Subject: Exhibition - Upper South Creek Advanced Water Recycling Centre (SSI-8609189)

Attachment 1 – EES on the Upper South Creek Advanced Water Recycling Centre (SSI-8609189) EIS and technical reports

**Figure 6-8 Existing case 1% AEP FFA peak flood levels and depths (538m<sup>3</sup>/s at Elizabeth Drive)**

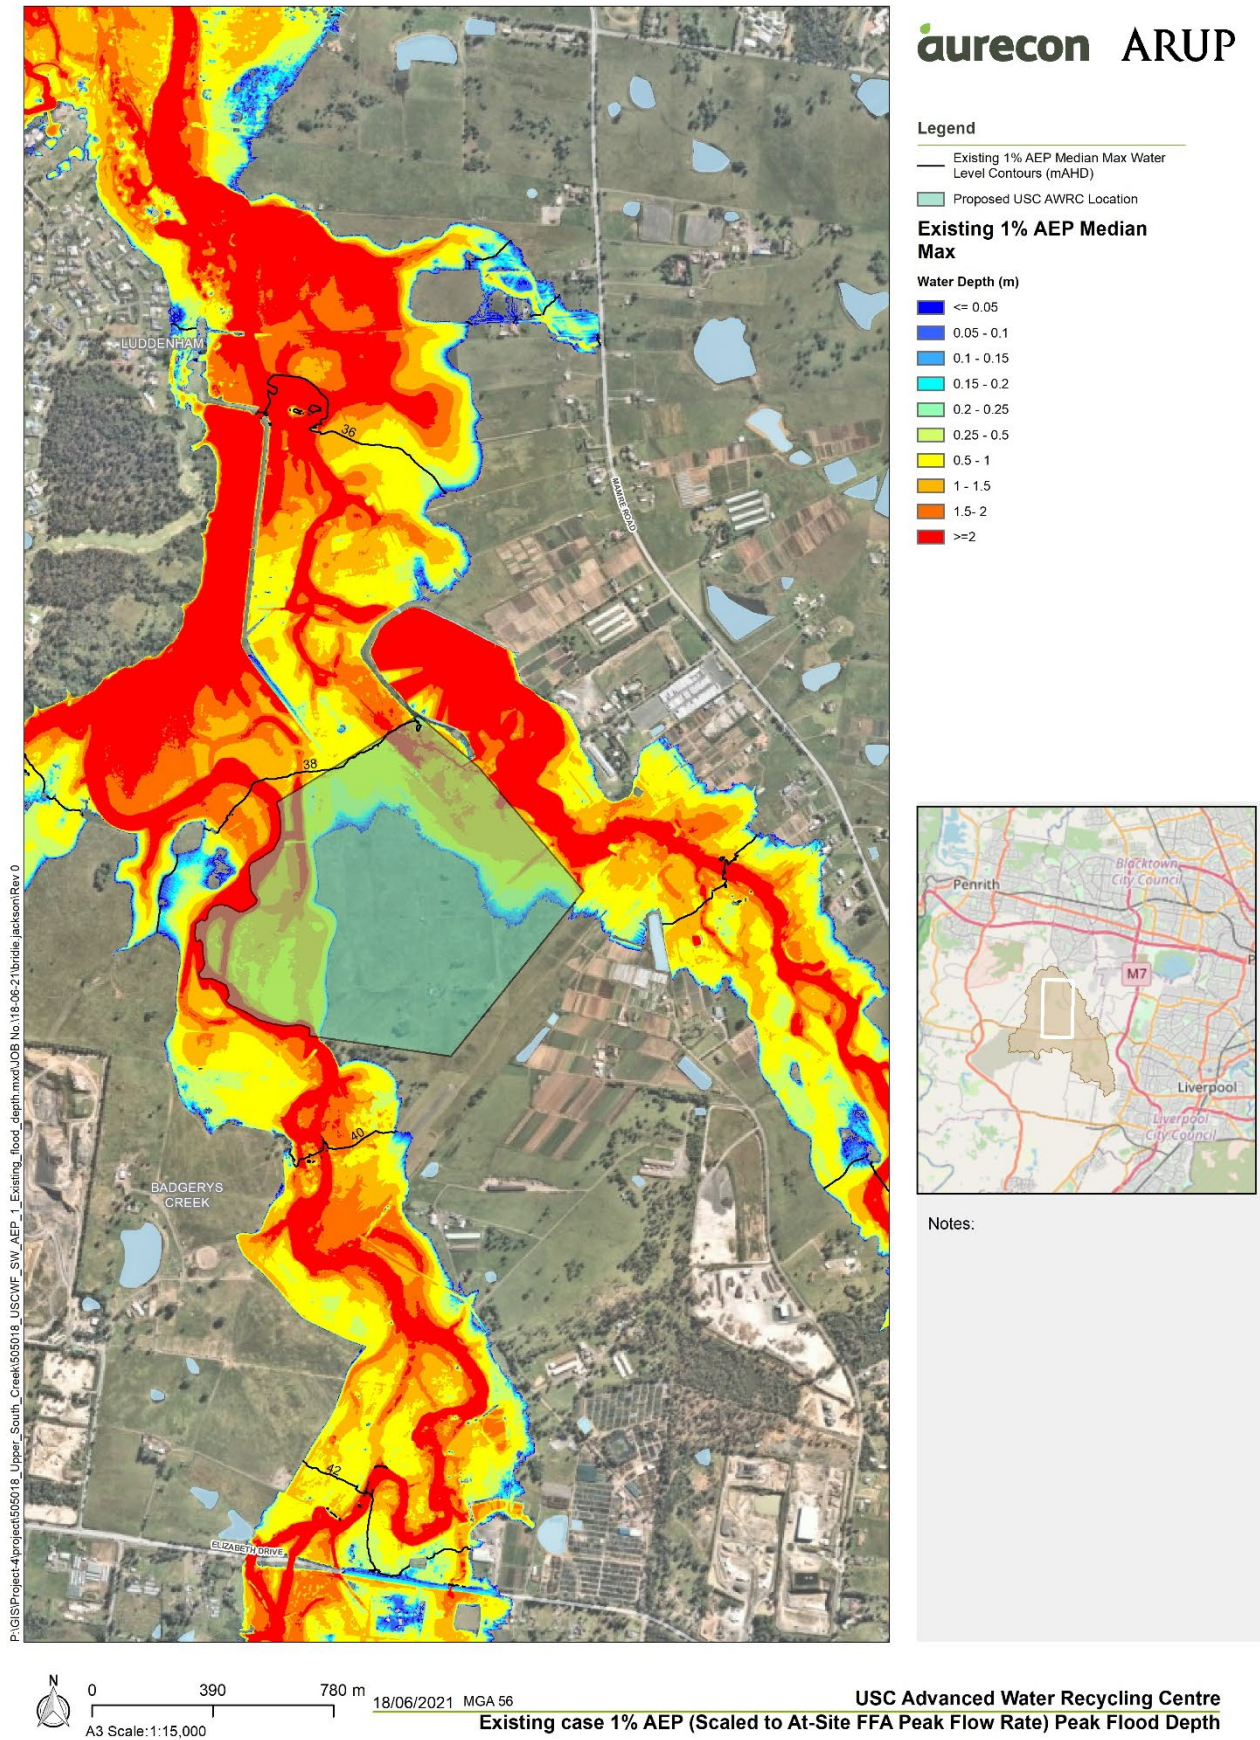
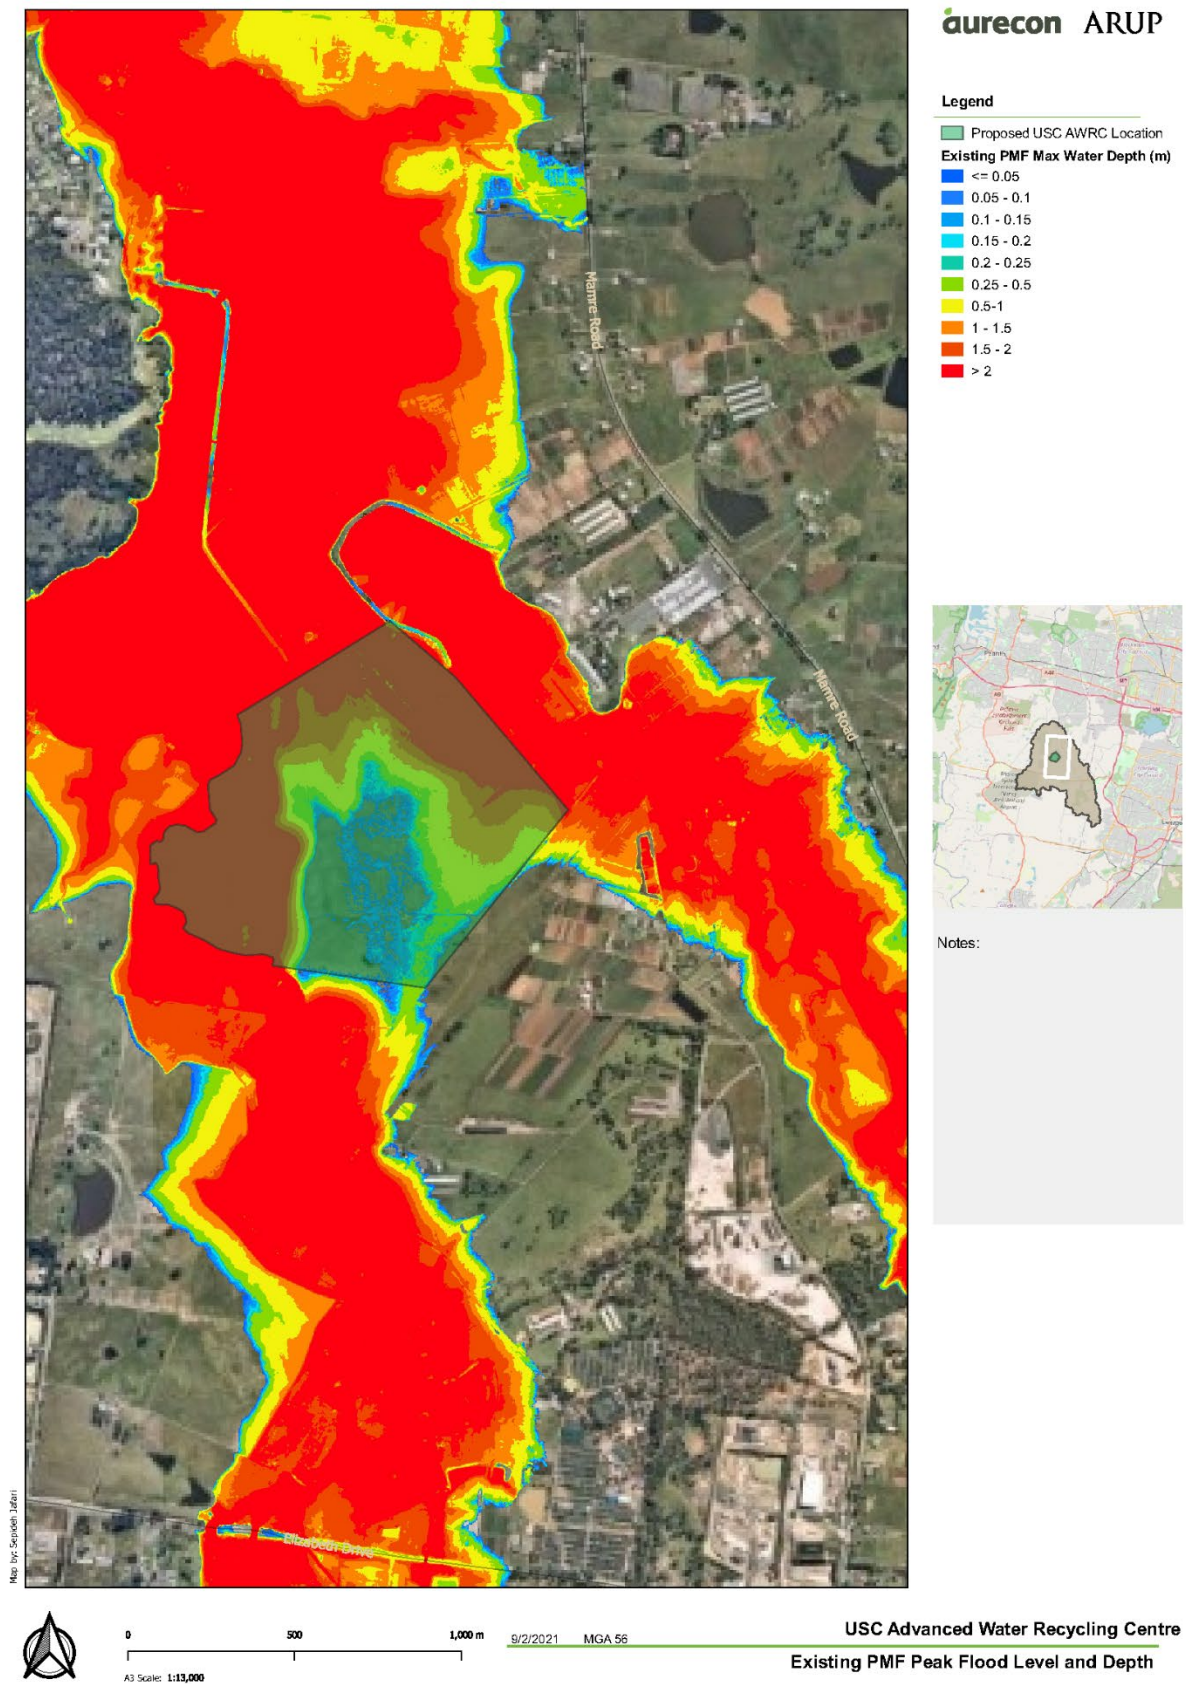
Accordingly, all results presented in Figures 6-4 to Figure 6-30 for the ‘Existing Case’ presented in Section 6.2 are not consistent with Penrith Council’s South Creek adopted Flood Study

(WorleyParsons, 2015). All reference in the titles of the figures presented in Section 6.2 that they are based on WorleyParsons (2015) are misleading and incorrect.

EES recommends the proponent amend the Flood Impact Assessment and adequately address the following requirements.

Identifying existing flood behaviour (pre-development condition) for the full range of floods up to and including the probable maximum flood. The FIRA should outline and map existing flood behaviour based on the *Wianamatta (South) Creek Catchment Flood Study - Existing Conditions* report (final, version H, 25 Nov 2020) which is consistent with Penrith City Council's adopted flood studies and flood risk management study and plan. INSW has previously provided this information to the proponent.
